I am writing as a parent of a child that attends Darlington Public School regarding the proposed development by the University of Sydney, MP 07_0158 – Abercrombie Street Precinct, Syd Uni. Darlington Public School is an inner city school servicing the suburbs of Chippendale, Darlington and parts of Redfern. The school is directly adjacent to the western border of the project.

Drawing title
GROUND FLOOR PLAN

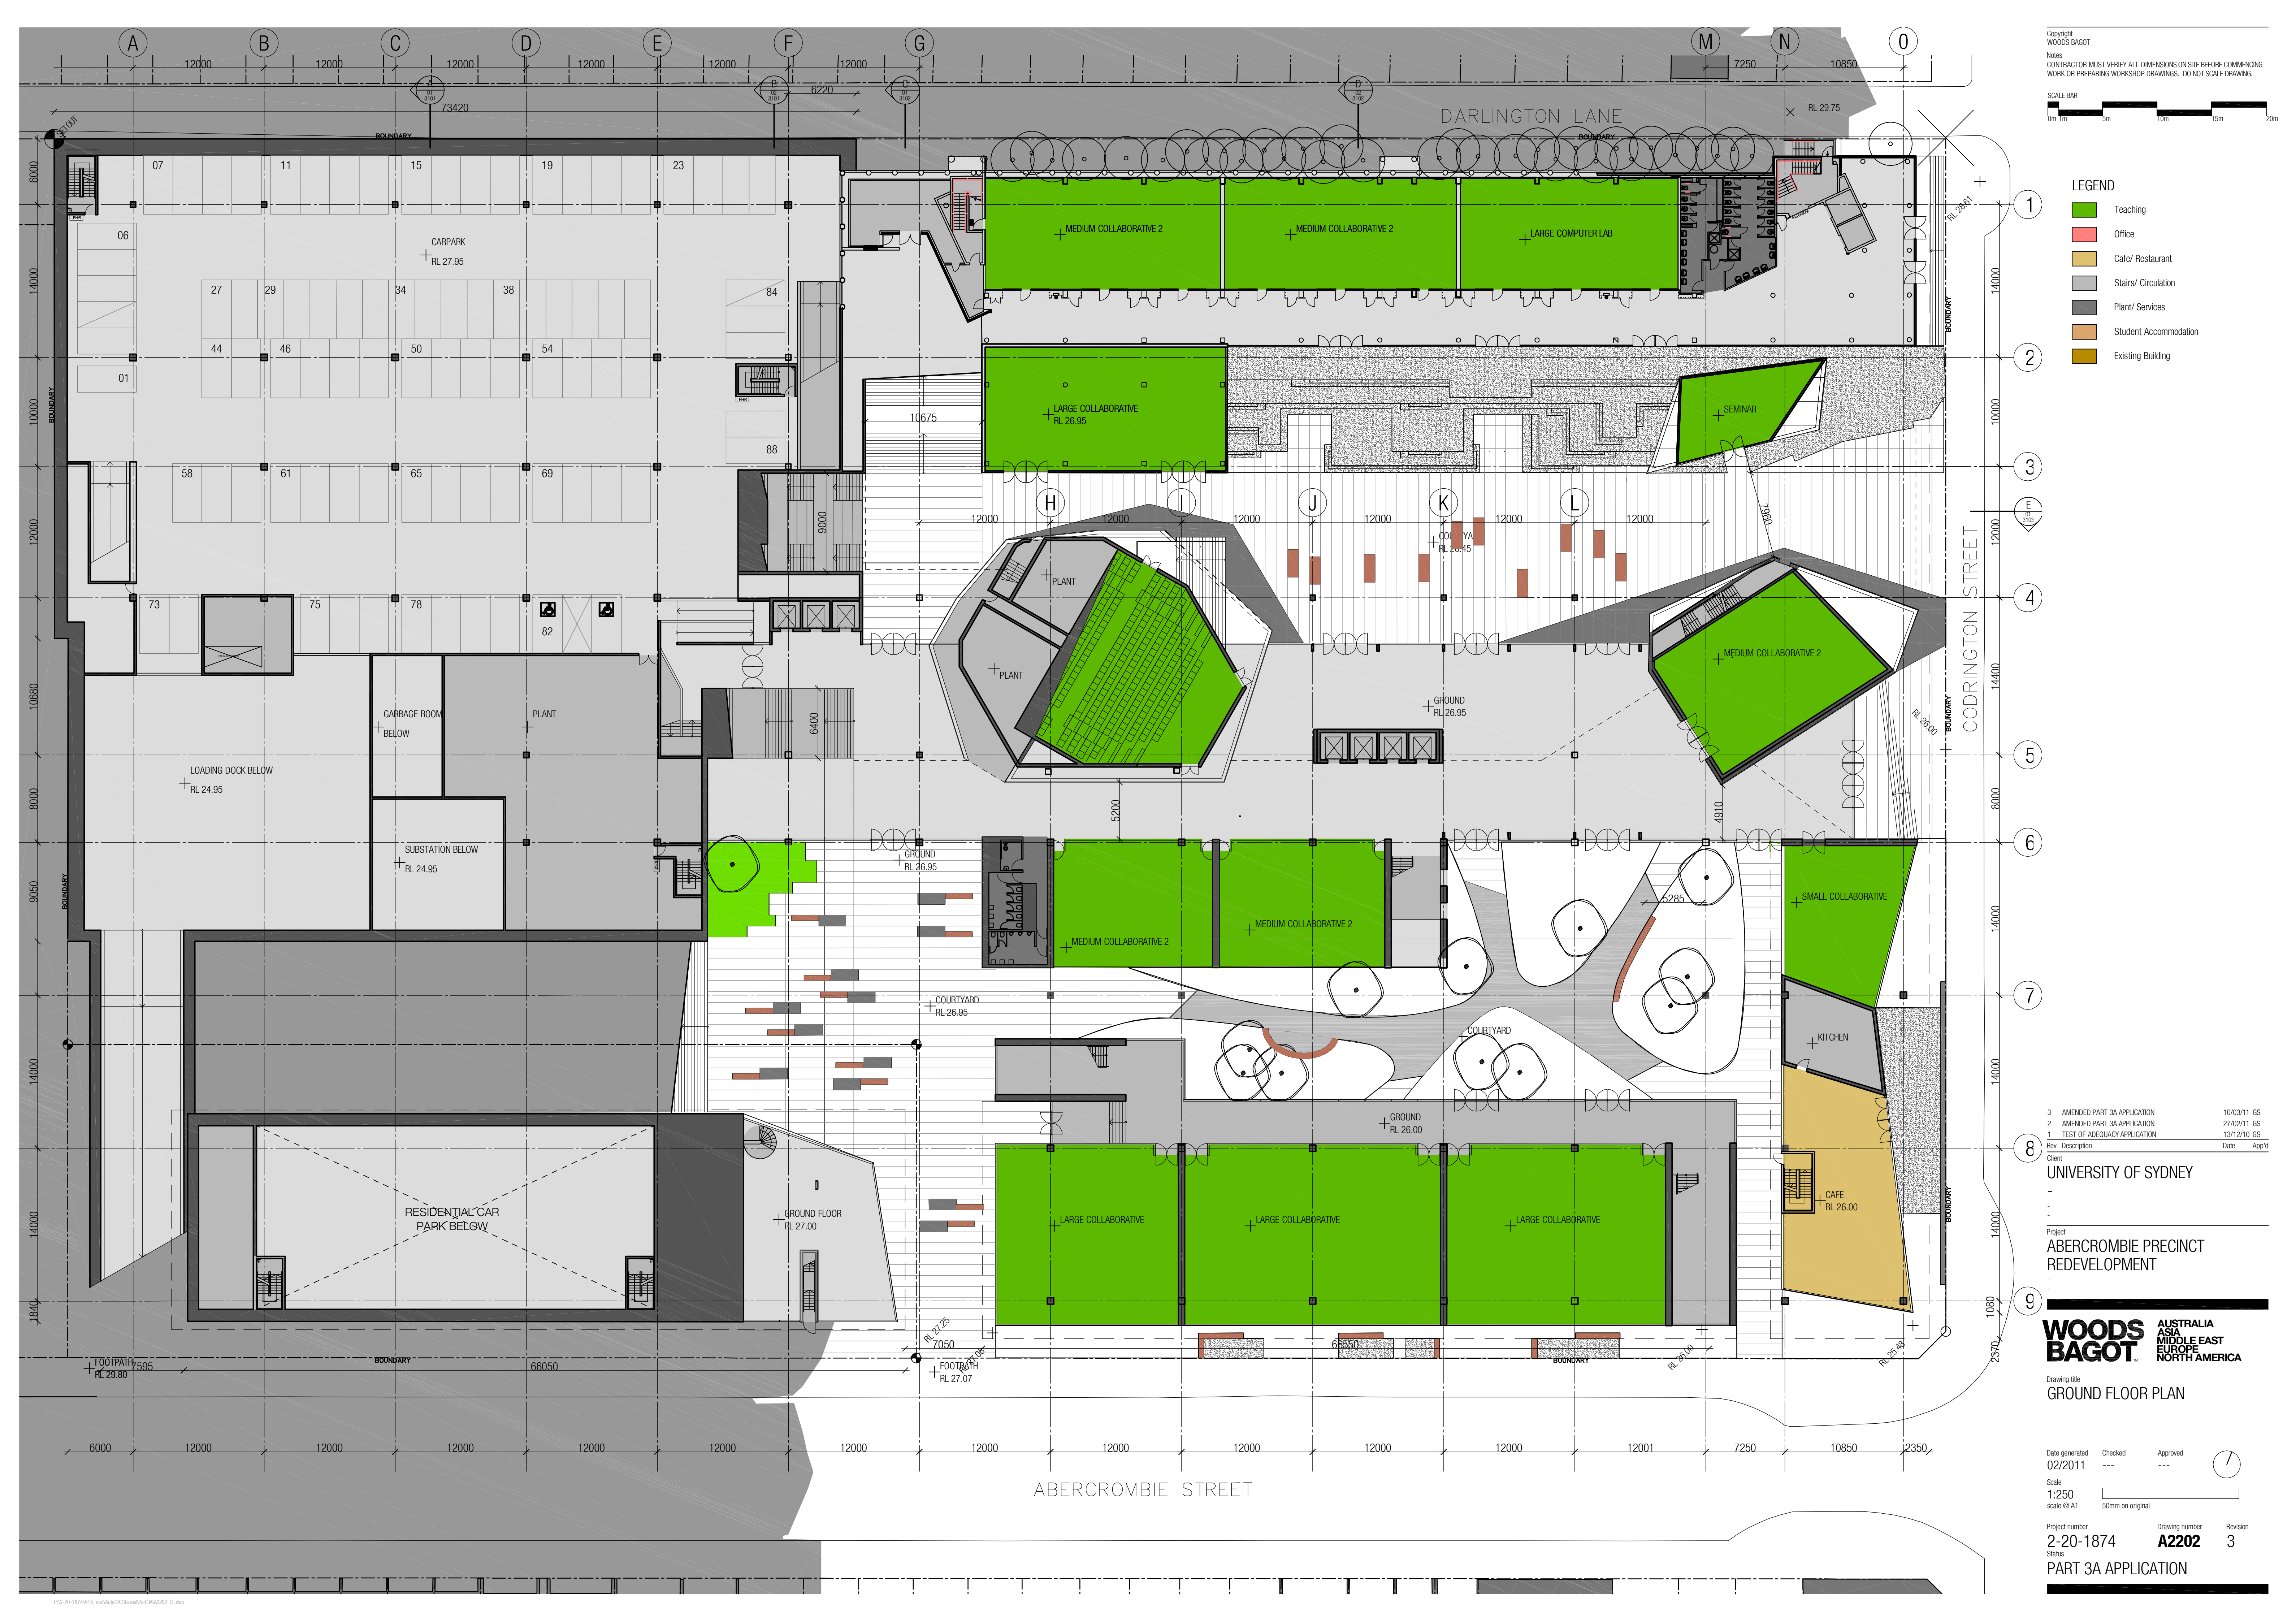
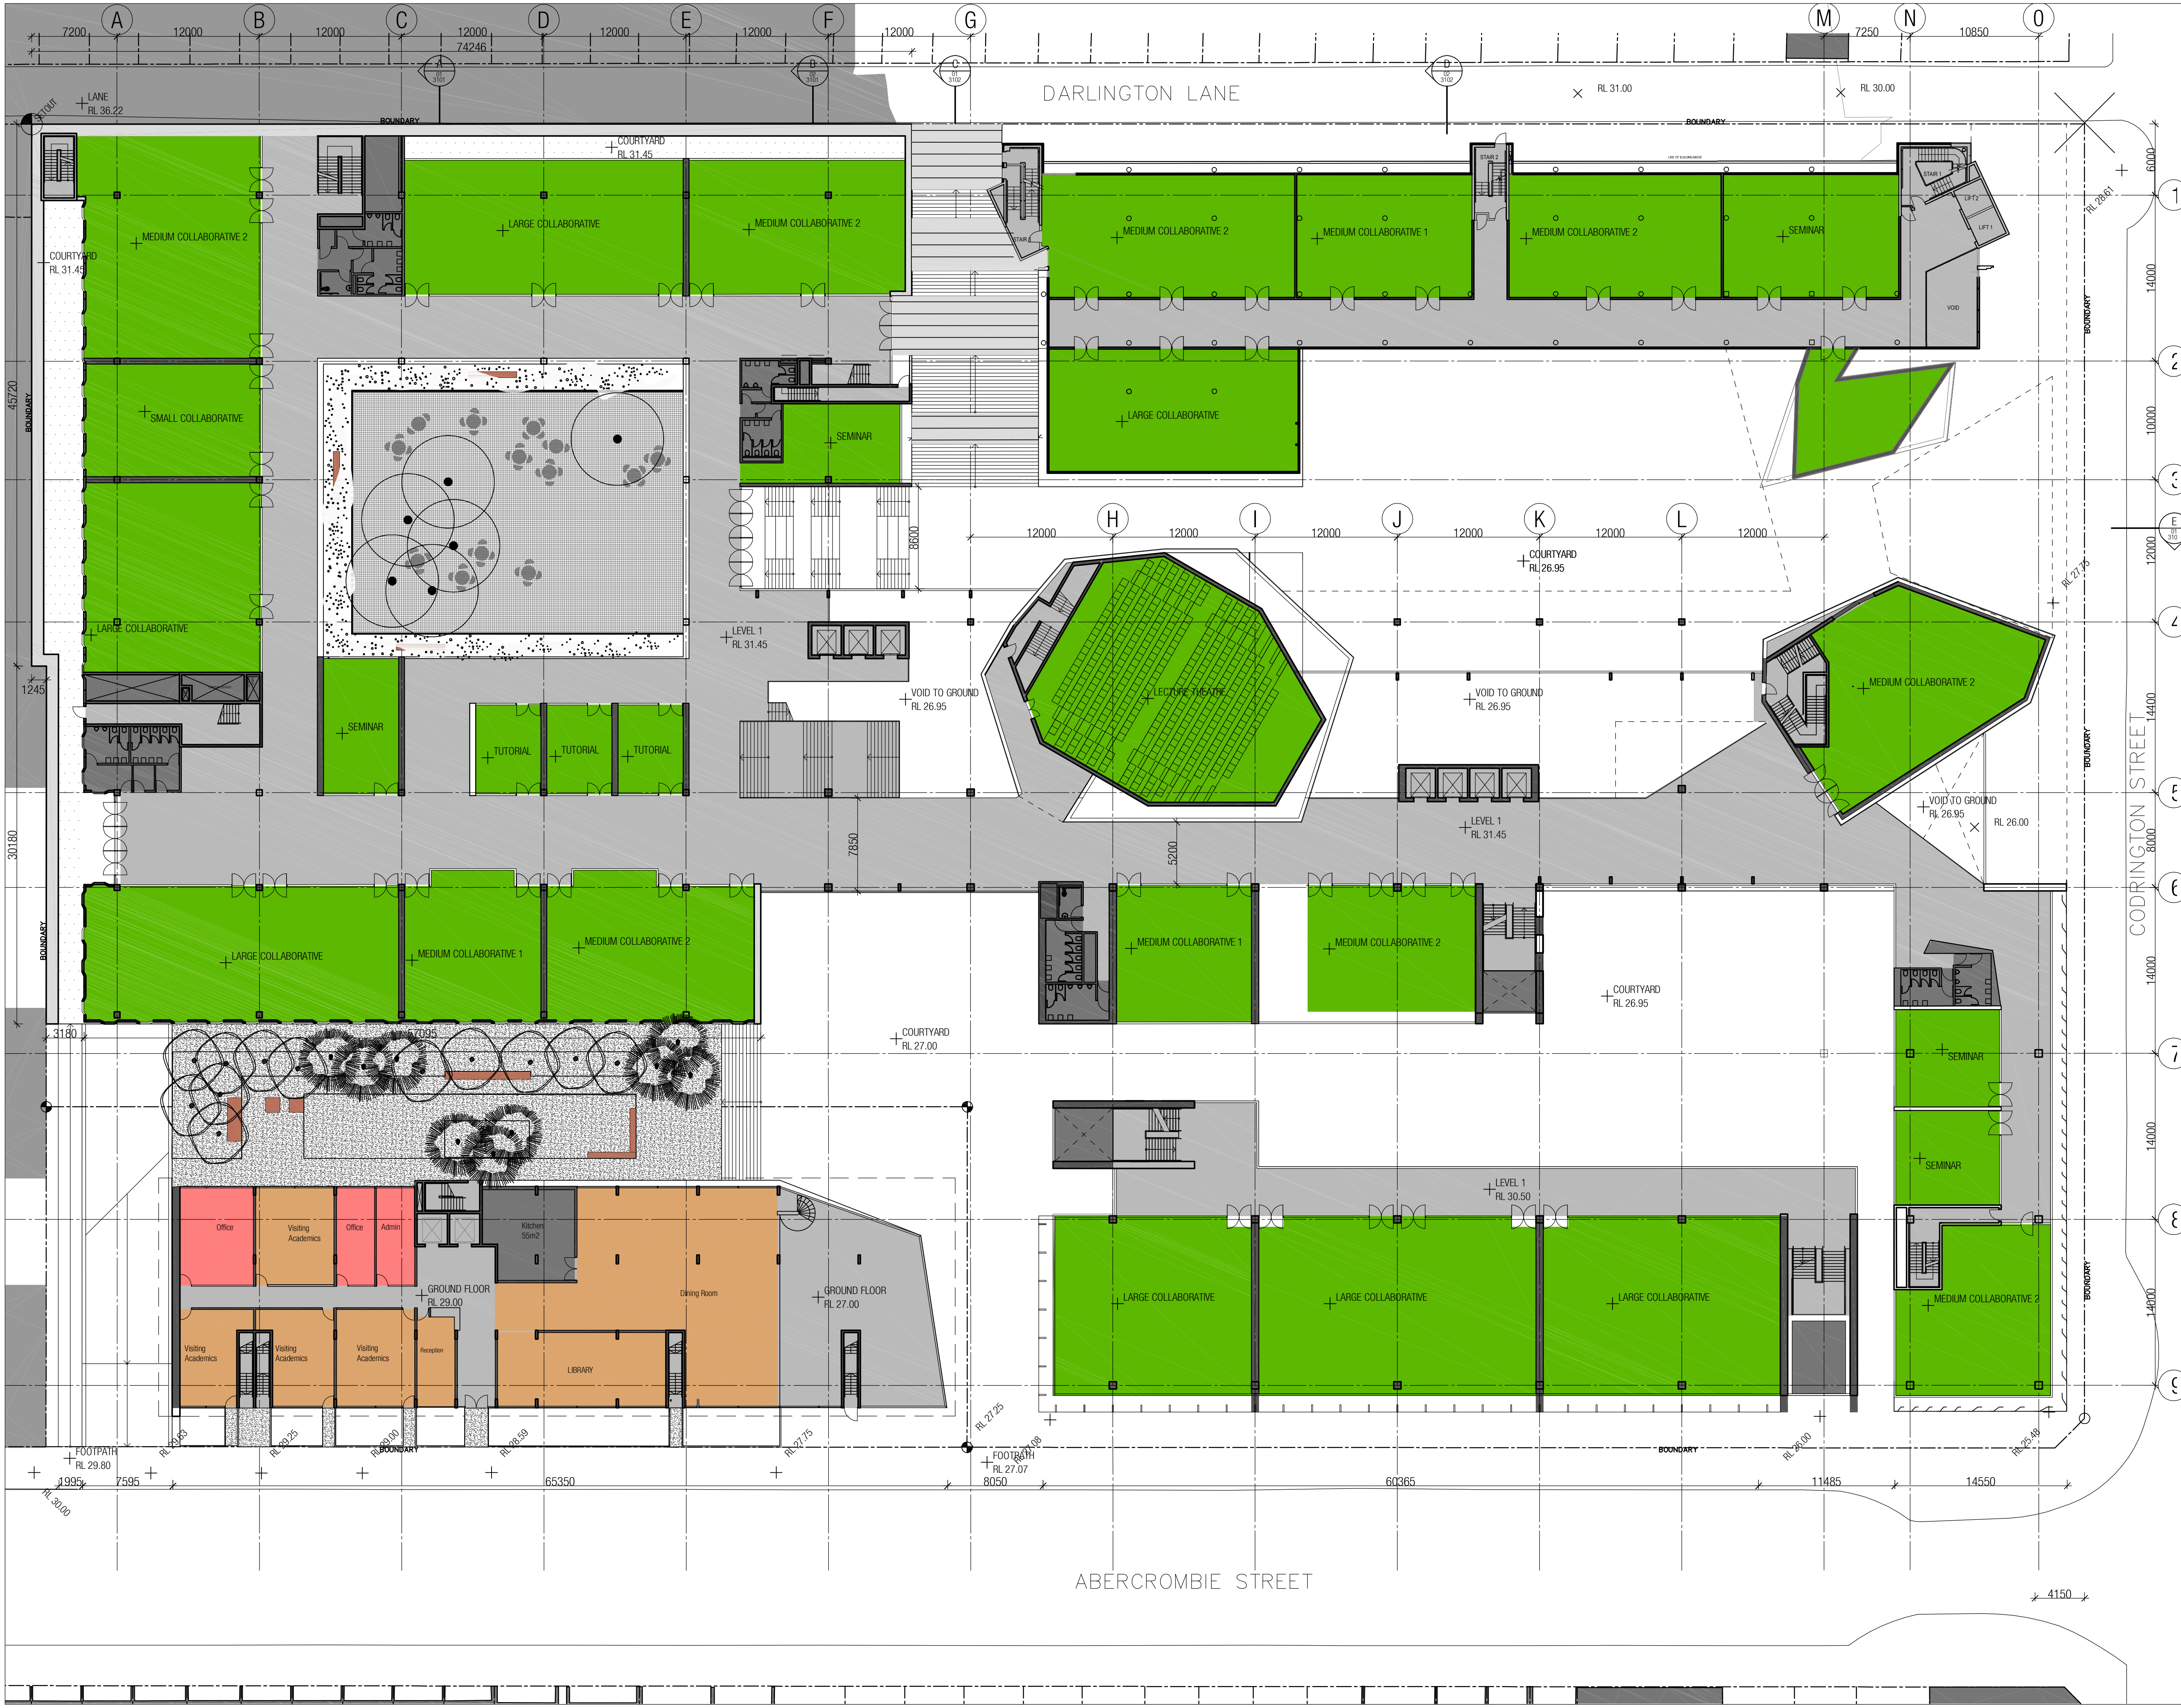
The proposed access point for the site is on Abercrombie Street and is directly adjacent to the school classrooms on their North East border of the school site. Locating the access point for trucks would:

- produce unacceptable levels of noise and vibration in the school classrooms that border that entrance – year 2, 4, 6 and both kindergarten classes. This is also particularly significant for the 2 kindergarten classrooms which face the development to the north with only glass panels and glass doors on that side.
- create an unsafe corridor for school children and parents that walk, or ride to school along Abercrombie Street (north side). This includes many unaccompanied but young children entering and leaving the school.
- create an unsafe car drop off and pick up point on Abercrombie Street (the main drop off point at the school).
- reduce the drop off and pick up point area for numerous children who are transported by car.

As per the current development plan, the proposal calls for an underground car park to be built for the student accommodation and University staff. The car park will accommodate 185 car spots, and its entrance will be on Abercrombie Street, at approximately the same point of the construction access.

The concerns raised above about the access point to the construction site are the same for this car park access point increasing the risk to school children's safety, in an area that has already been highlighted through the respective organisations (Council, Police, and RTA). The increased traffic flows and access point are an unacceptable risk to the children who attend the school. There is no justification for this level of risk to a school community, particularly as the University has another street frontage without school or residential issues (the University being the only stakeholder for Codrington Street) and an access street internal to project (Darlington Lane).
